Subject: **Revised Request for Modification to Individual Section 404 and Section 401 Water Quality Certification** for the proposed construction of an extension of SR 1163 (Old Georgetown Rd) from SR 1184 (Ocean Isle Beach Rd) to NC 179 in Brunswick County, State Project 6.231023, TIP R-3432. Debit \$570.00 from WBS 35501.1.1

The purpose of this letter is to revise the permit modification request, dated October 1, 2015, for the above referenced 404 Permit and 401 Water Quality Certification. Please replace the permit drawings provided with our latest request with the enclosed revised copies.

**WETLAND & SURFACE WATER
PERMIT DRAWING
REVISED 10/08/2015**

PERMIT DRAWING
SHEET 3 OF 29

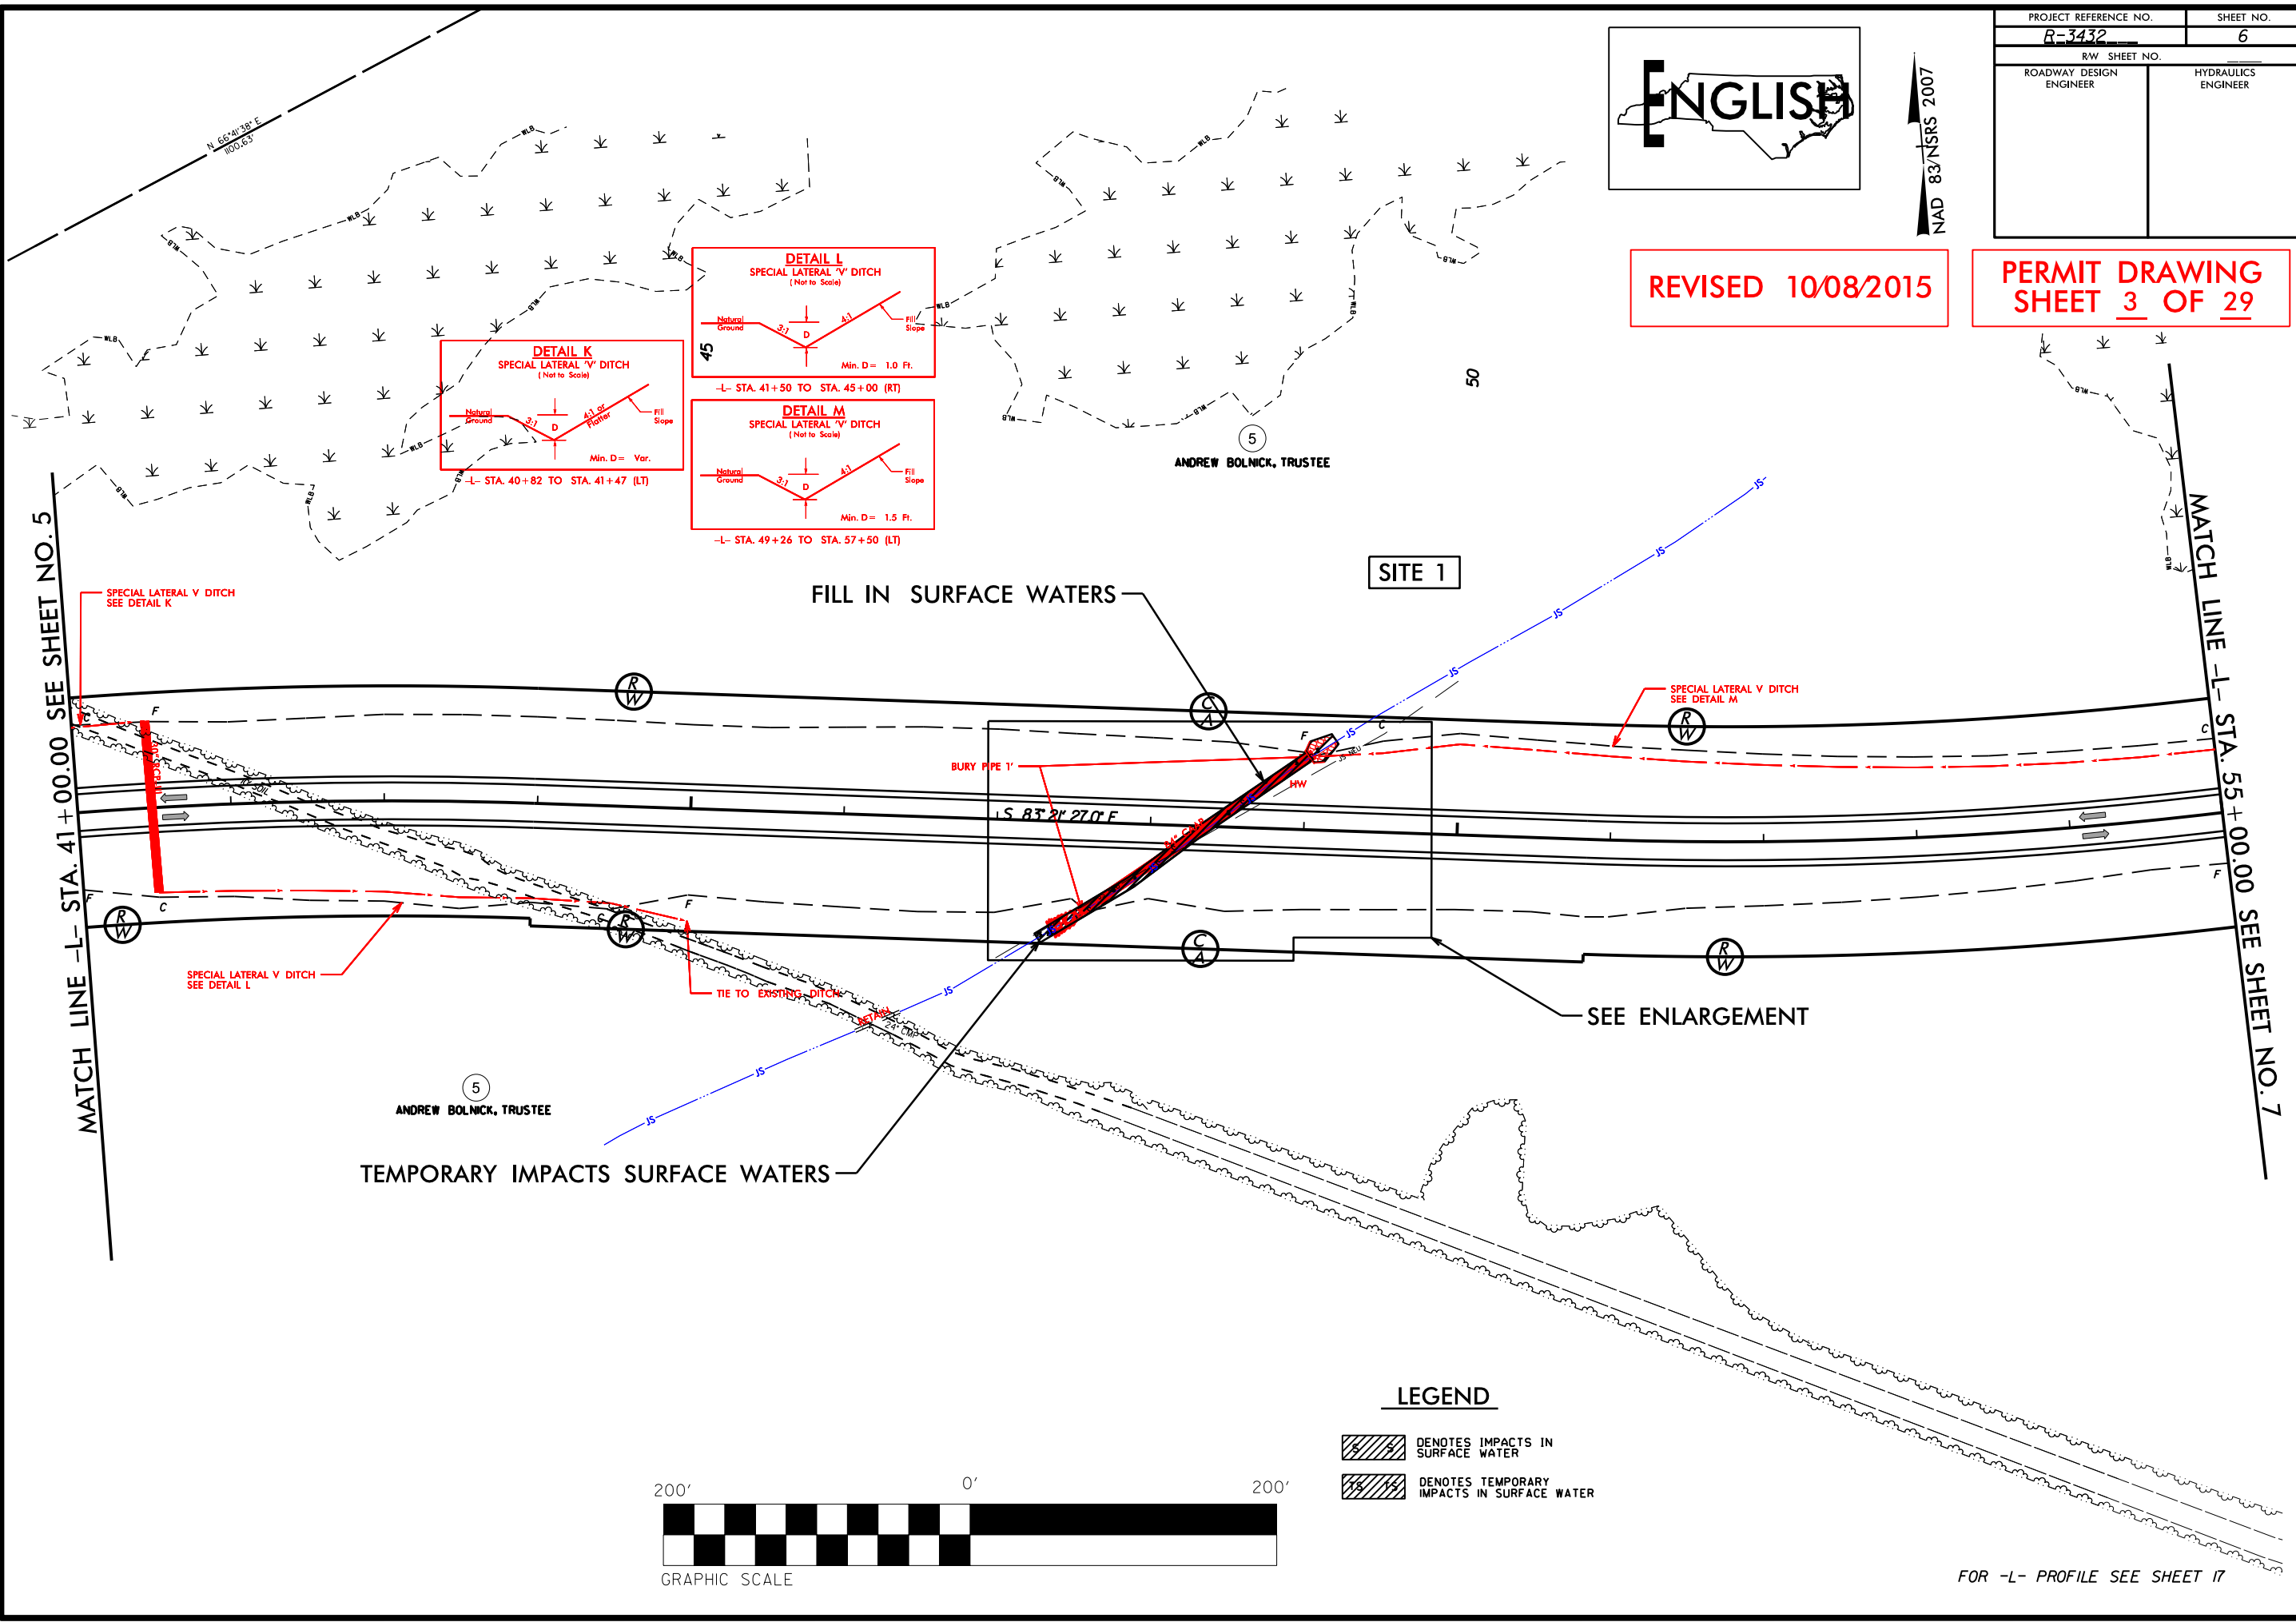
- Site 1. Additional riprap will be added at the inlet of the 84" CAAP. Surface water impacts will increase by 0.1 acre;
- Site 2. The ditch block and special lateral ditch from Site 2 to the ditch block at 100+50 LT will be removed. No additional impacts to jurisdictional resources;
- Site 3. Riprap will be added to line the ditch from Station 106+00 to 108+67 LT, additional riprap will be added at the inlet of the main culvert to fill in the hole

PERMIT DRAWING
SHEET 8 OF 29
REVISED 10/12/2015

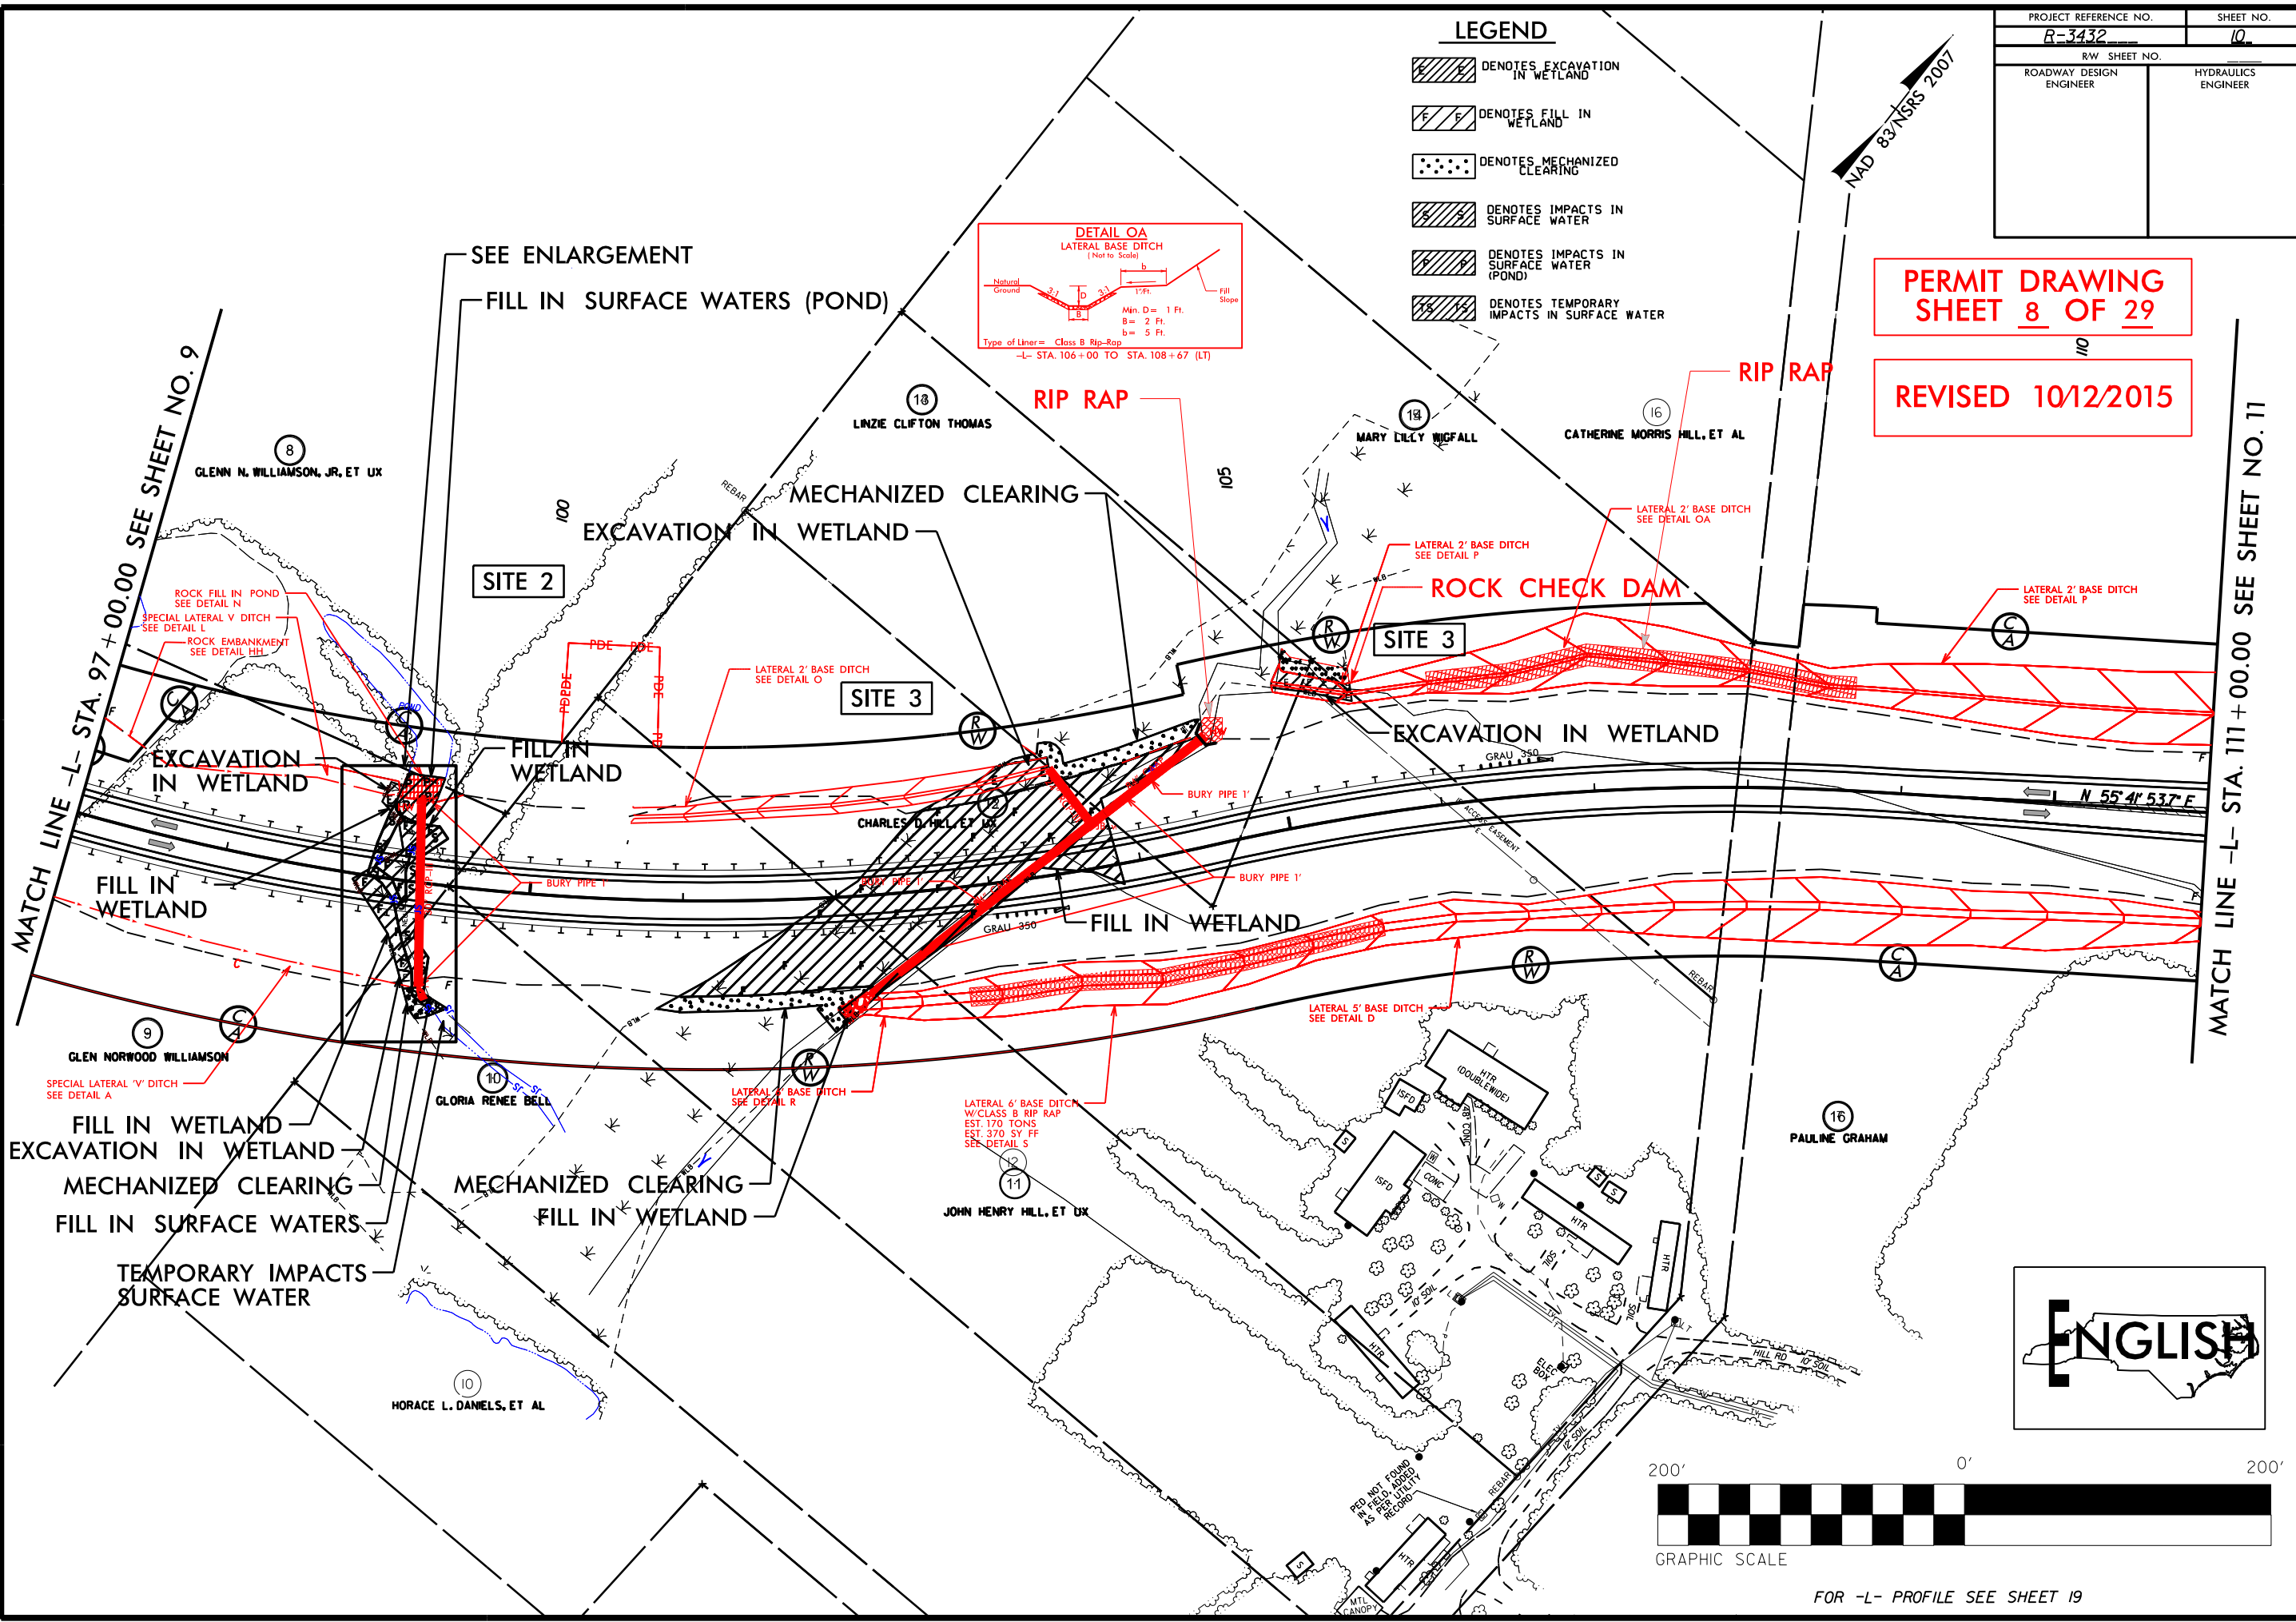
created by construction of the culvert, headwall, and wing walls. There are no additional impacts to jurisdictional resources;
